From: Sue Howell
Sent: 06 March 2019 10:16
To: Planning.Responses
Cc: Simon Davis
Subject: RE: Planning Consultation on AL/20/19/DOC

APPLICATION NO: AL/20/19/DOC

Registered: 25-FEB-19
Site Address: The Gospel Hall Nyton Road Aldingbourne
Tangmere PO20 3TX

Condition No 4 landscaping scheme.

BOGNOR
BG.8.03.M

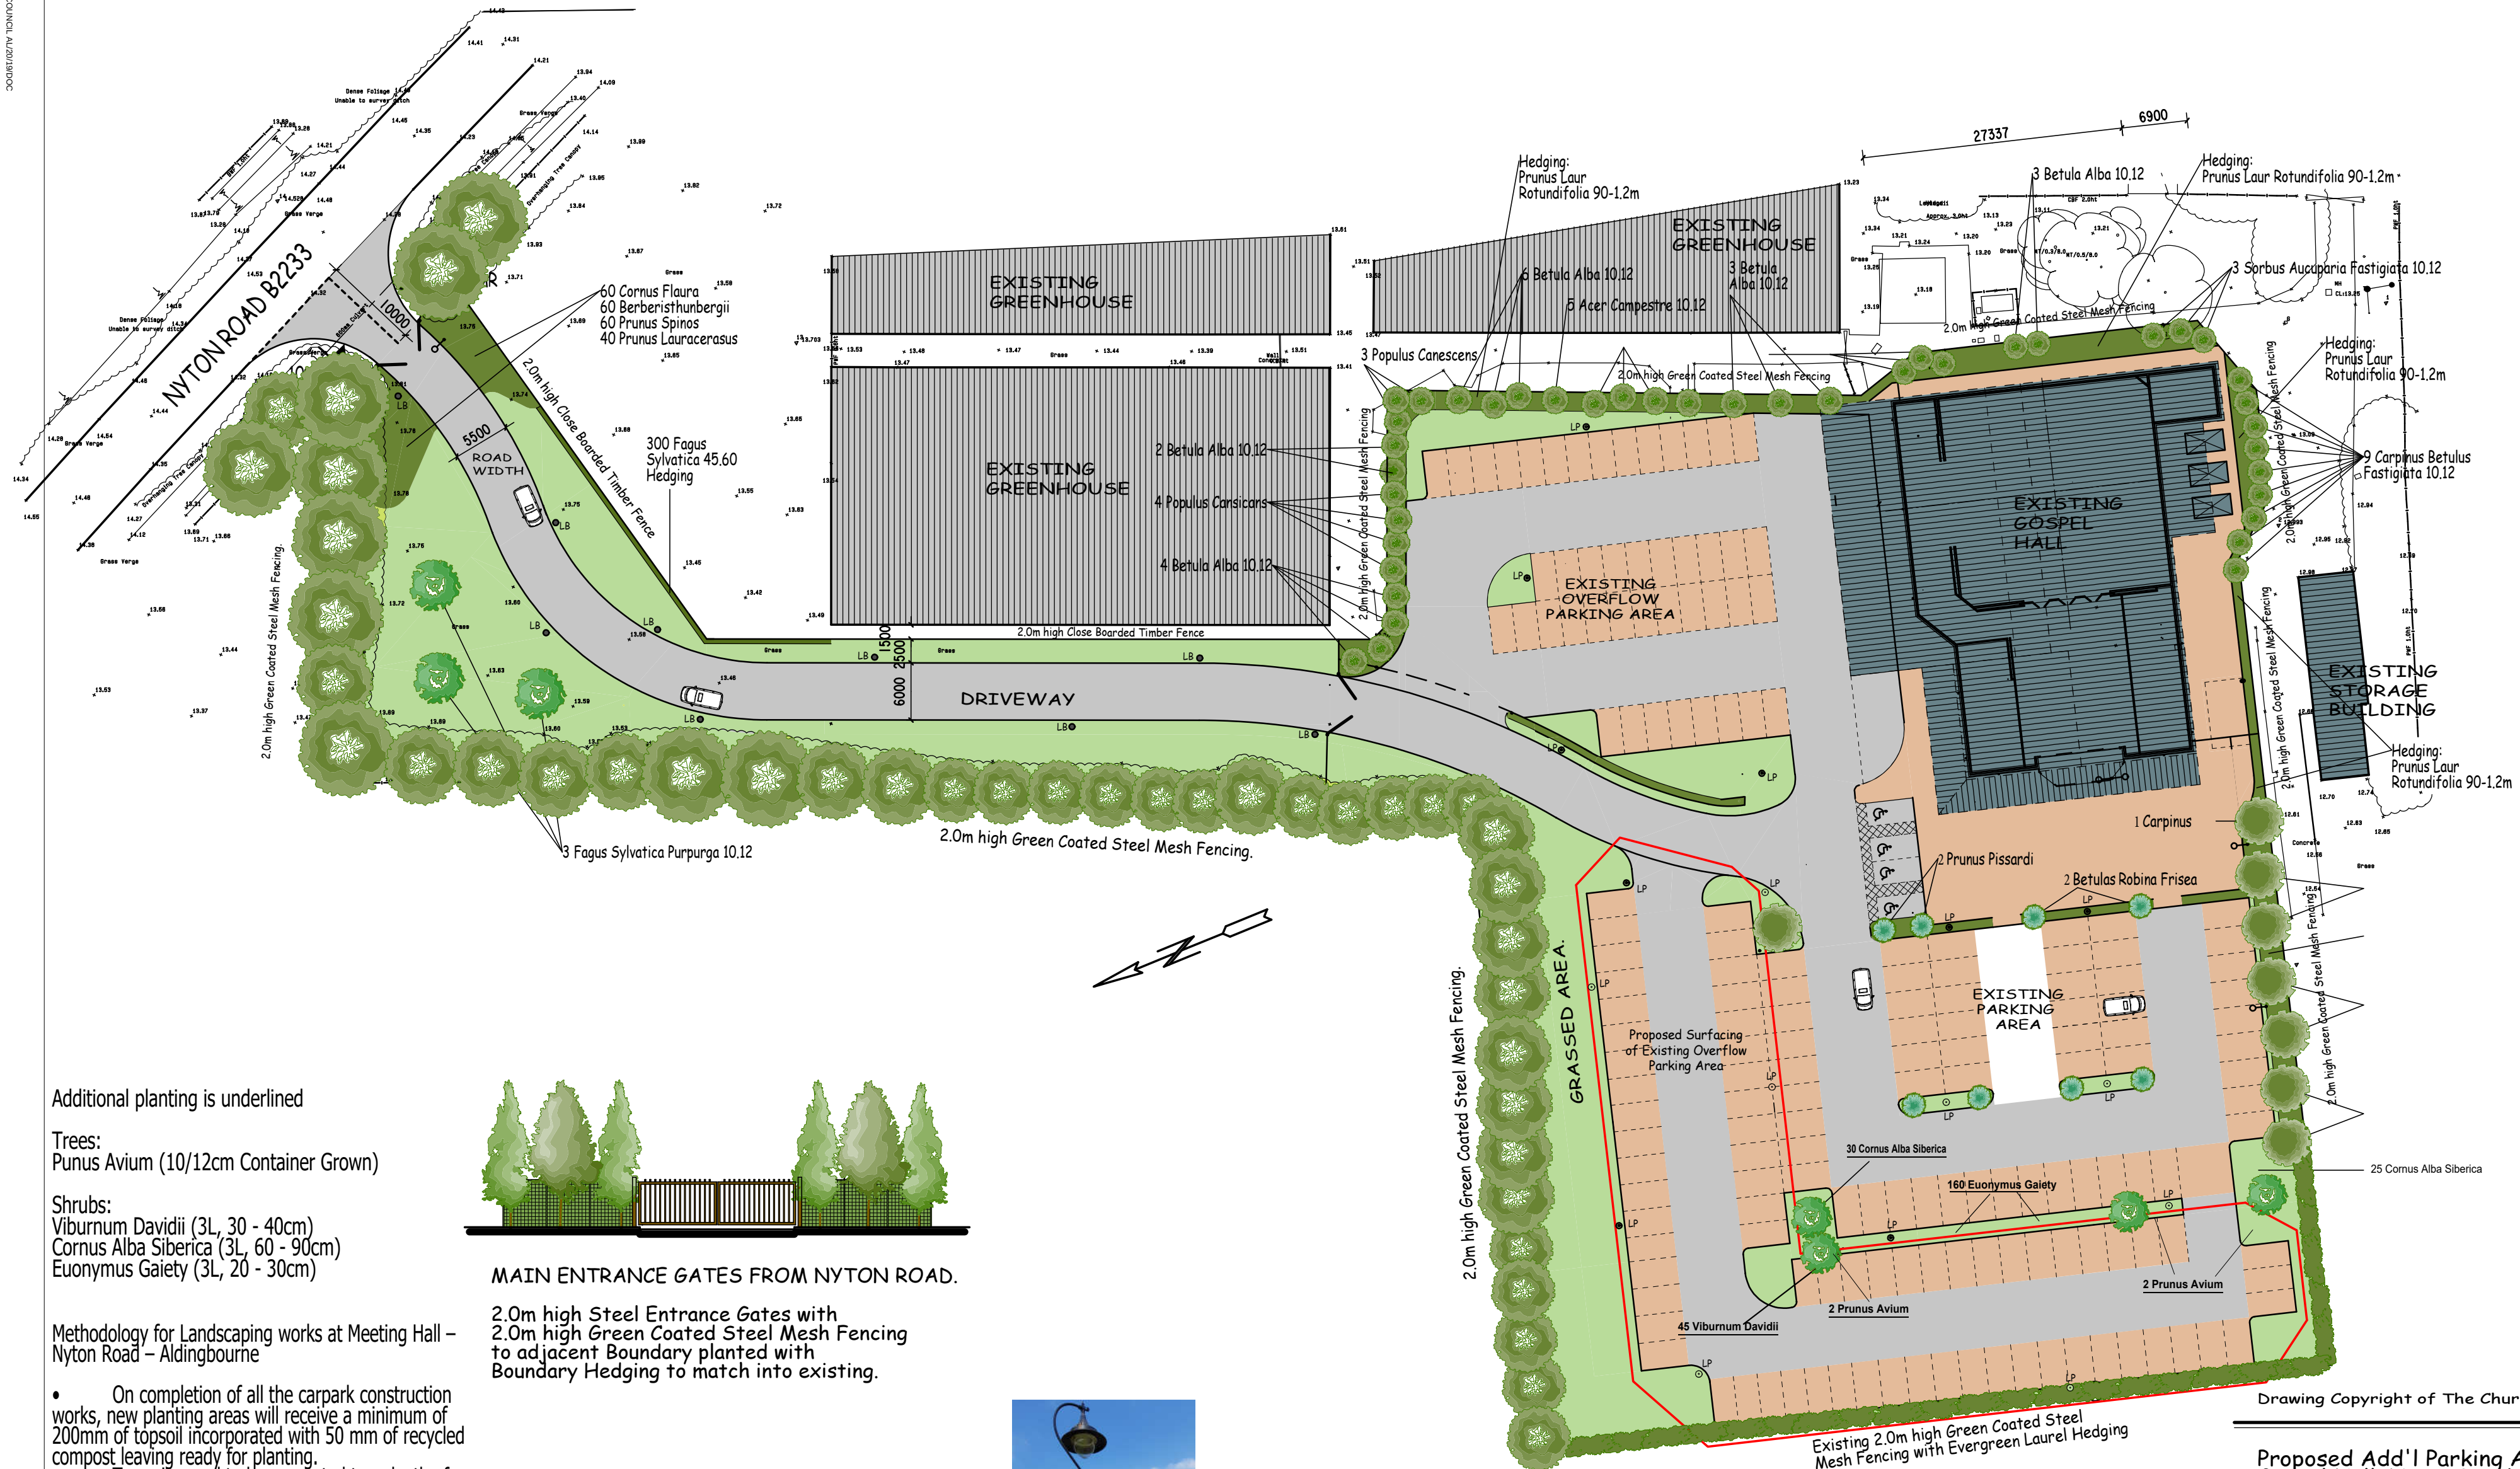
The information supplied in Dwg BG.8.03.M sets out the planting for the site, but it is a little unclear which is existing and which is the new proposed planting as part of this application.

I would recommend that further detail is provided to highlight which is the new planting with a detailed schedule also of quantities, species choice and size at time of planting.
